From: Andrew Wood
Sent: 20 December 2018 16:29
To: Planning.Responses
Subject: FW: FG/140/18/DOC - Landscaping Plan

COMMENT ON DOC APPLICATION

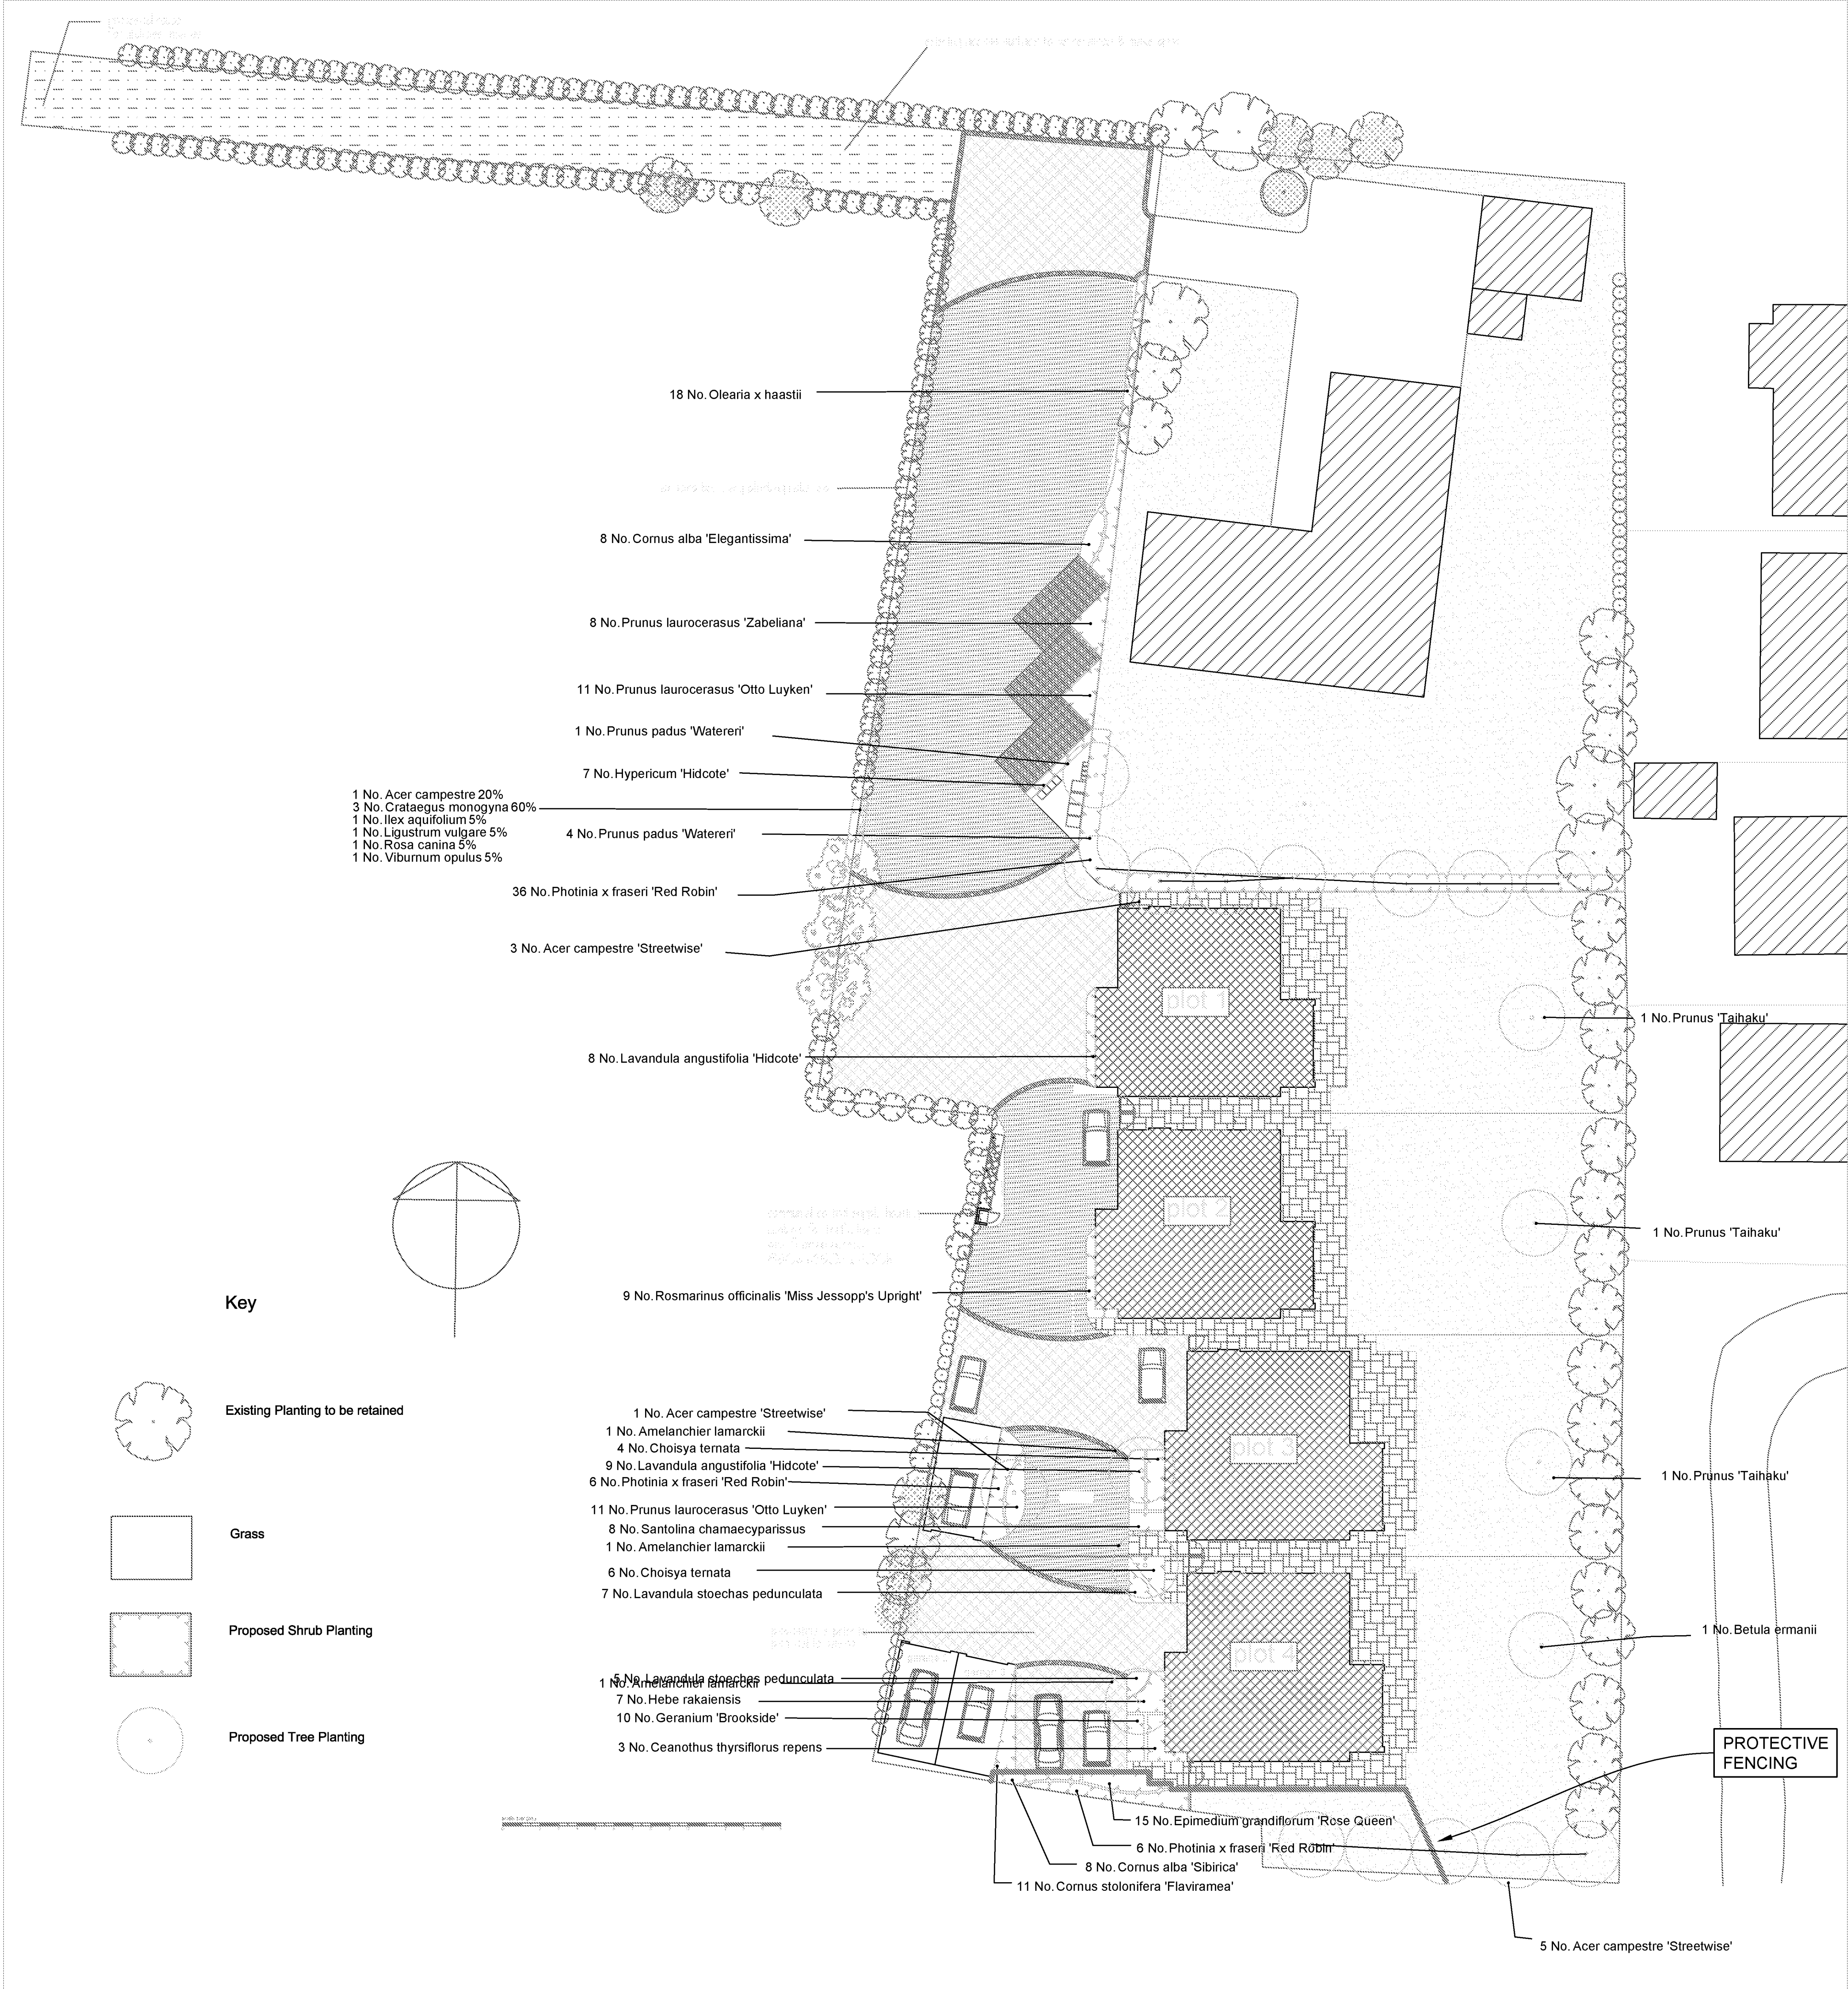
Thank you for your time earlier. As you know I was unhappy to agree with your decision of the 2m height on the eastern boundary as this was never approved by myself whilst in discussions with the developer (case not closed) . I also agreed that the boundary between plot 1 and 44 Ferringham lane (south boundary) will have no height restriction nor will have any particular finish. This is my boundary and I will not honour any requests to reduce or cut down this boundary ever. Please ensure that at the point of approval that this boundary has no restriction. I have discussed this particular boundary with the developer extensively and we both agree that this will always be the case- a very large screen to avoid any direct viewing from plot 1 to 44 Ferringham lane.
